M25 junction 28 improvement scheme

TR010029

9.47 Applicant's comments on responses to Transport for London D3a Response

9.47 Applicant's comments on responses to Transport for London D3a Response

Client		Project		GROVE FARM ACCESS, JUNCTION 28 M25 NORTHBOUND SLIP LANE	
MR L JONES & MRS K JONES		Title		ACCESS ALTERATIONS TO GROVE FARM	
Status	Drawn	Scale	Sheet Size	Date	Drawing No.
FOR APPROVAL	PL	1:1000	A3	JAN 2021	REDW-3396-110
				Rev

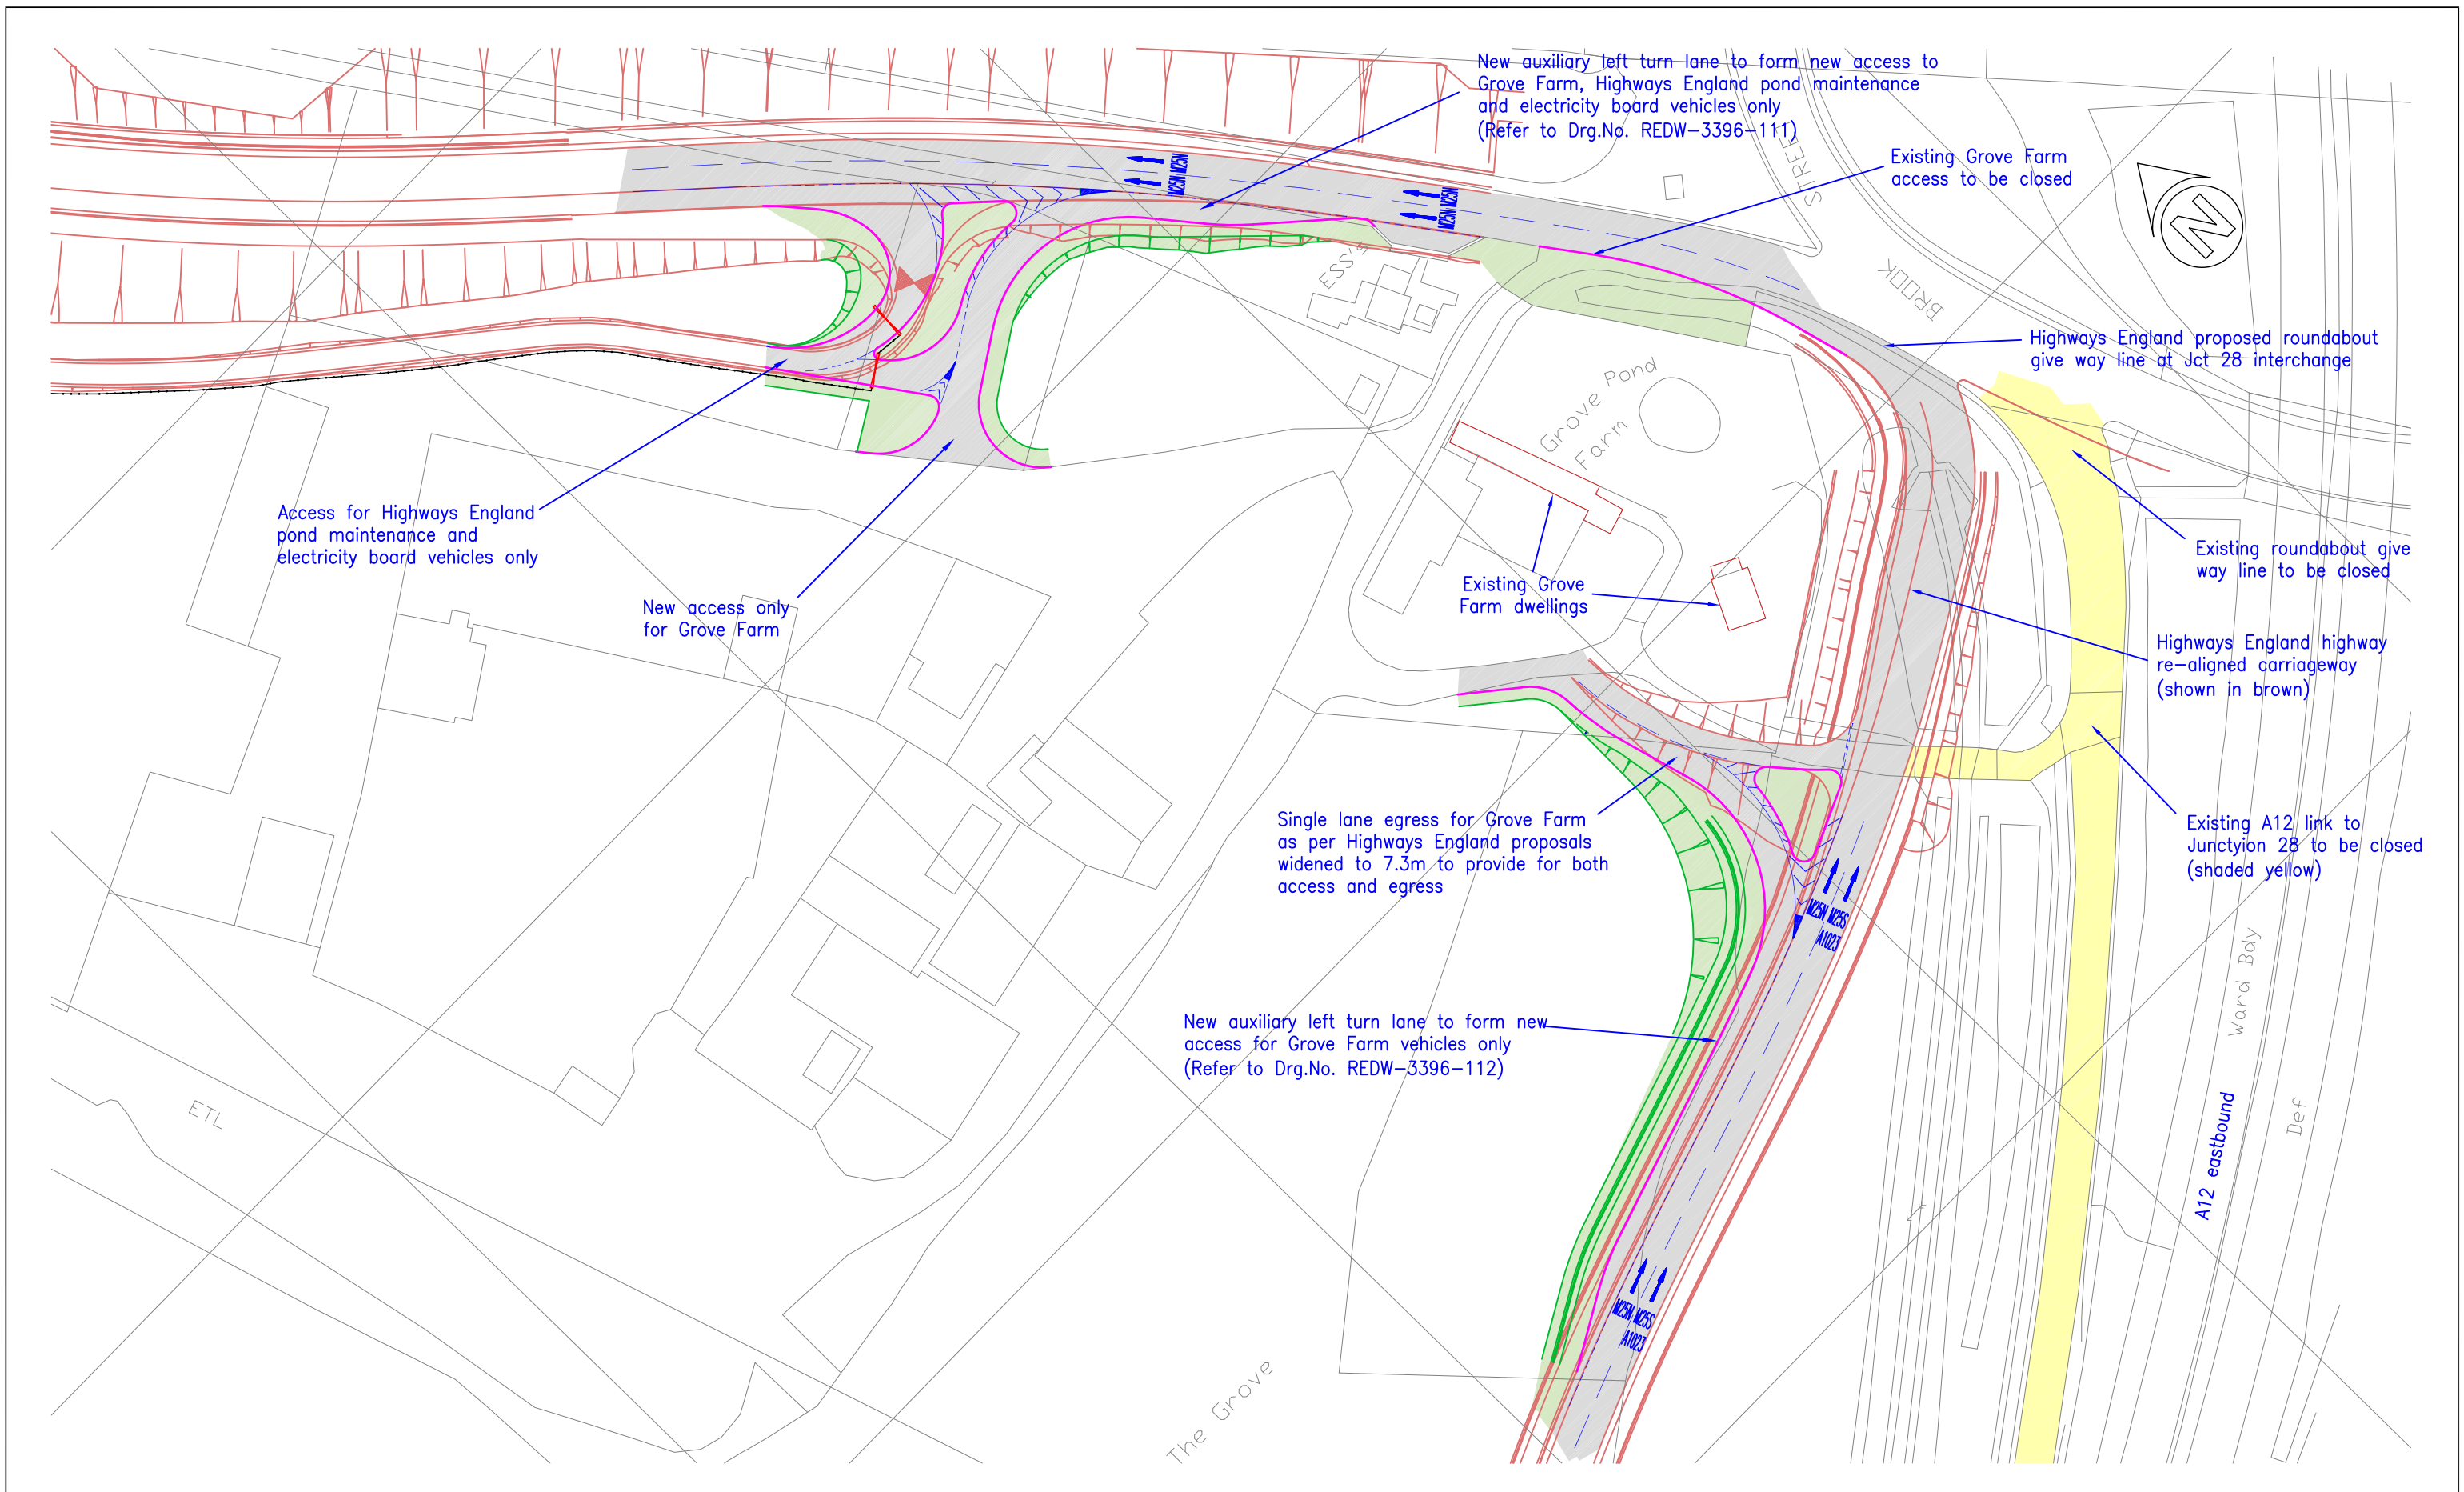
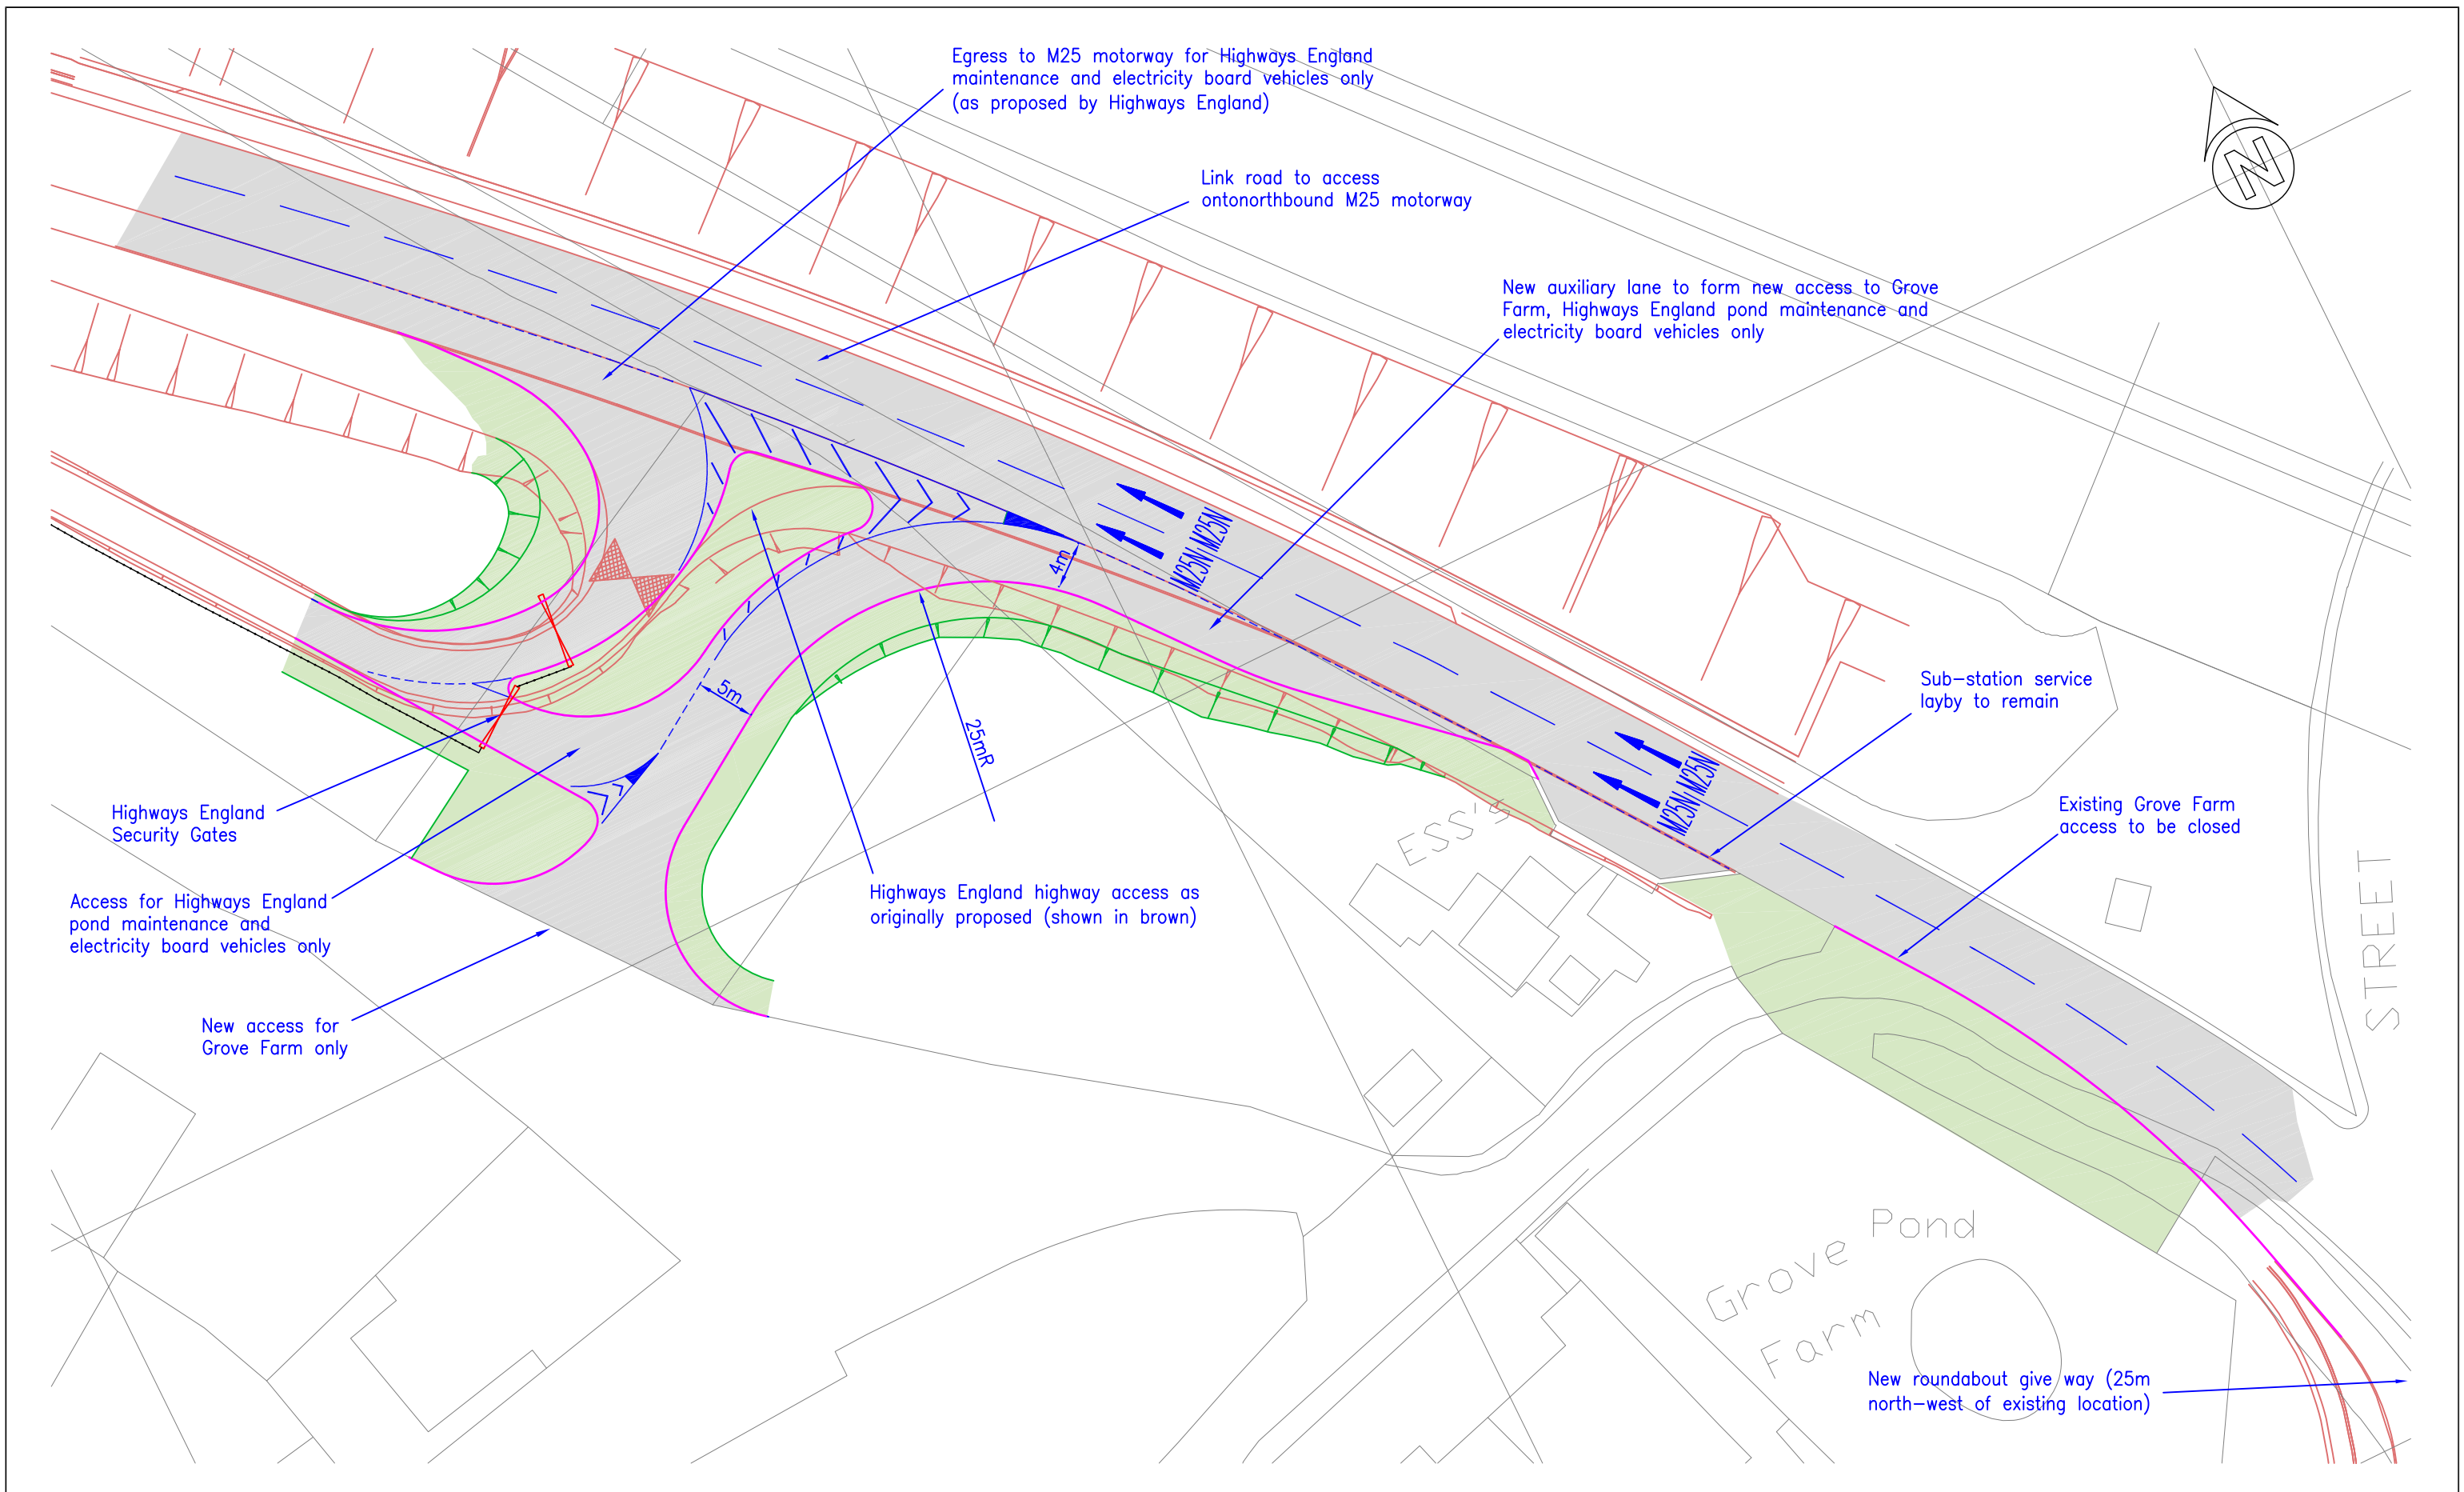
REP3A-046-11	<p><u>3. Responses on Written Representations</u></p> <p><u>Grove Farm</u></p> <p>3.2 Work No. 15 of the draft DCO involves the re-provision of the egress route from Grove Farm onto the new A12 eastbound off slip road. The draft DCO requires that TfL will be responsible for the ownership and maintenance of the new slip road.</p> <p>3.3 The Written Representation from Grove Farm includes proposals for access to the farm to be provided from the new A12 eastbound off slip road as well as from the M25 northbound on slip road, with a new auxiliary lane on the left of the A12 eastbound off slip road providing this access. TfL wishes to understand the Applicant's views on this proposal and TfL reserves its position until it has a fuller understanding of the implications including any road safety impacts. TfL does not seek to take on further maintenance liabilities beyond those already imposed by the draft DCO</p>	<p>Highways England's response to Grove Farm's proposal is set out in pages 51 to 67 of Highways England's response to Written Representations (REP3A-022). In short, Highways England does not consider that it would be appropriate for an access to be provided to Grove Farm from the A12 eastbound off slip.</p>
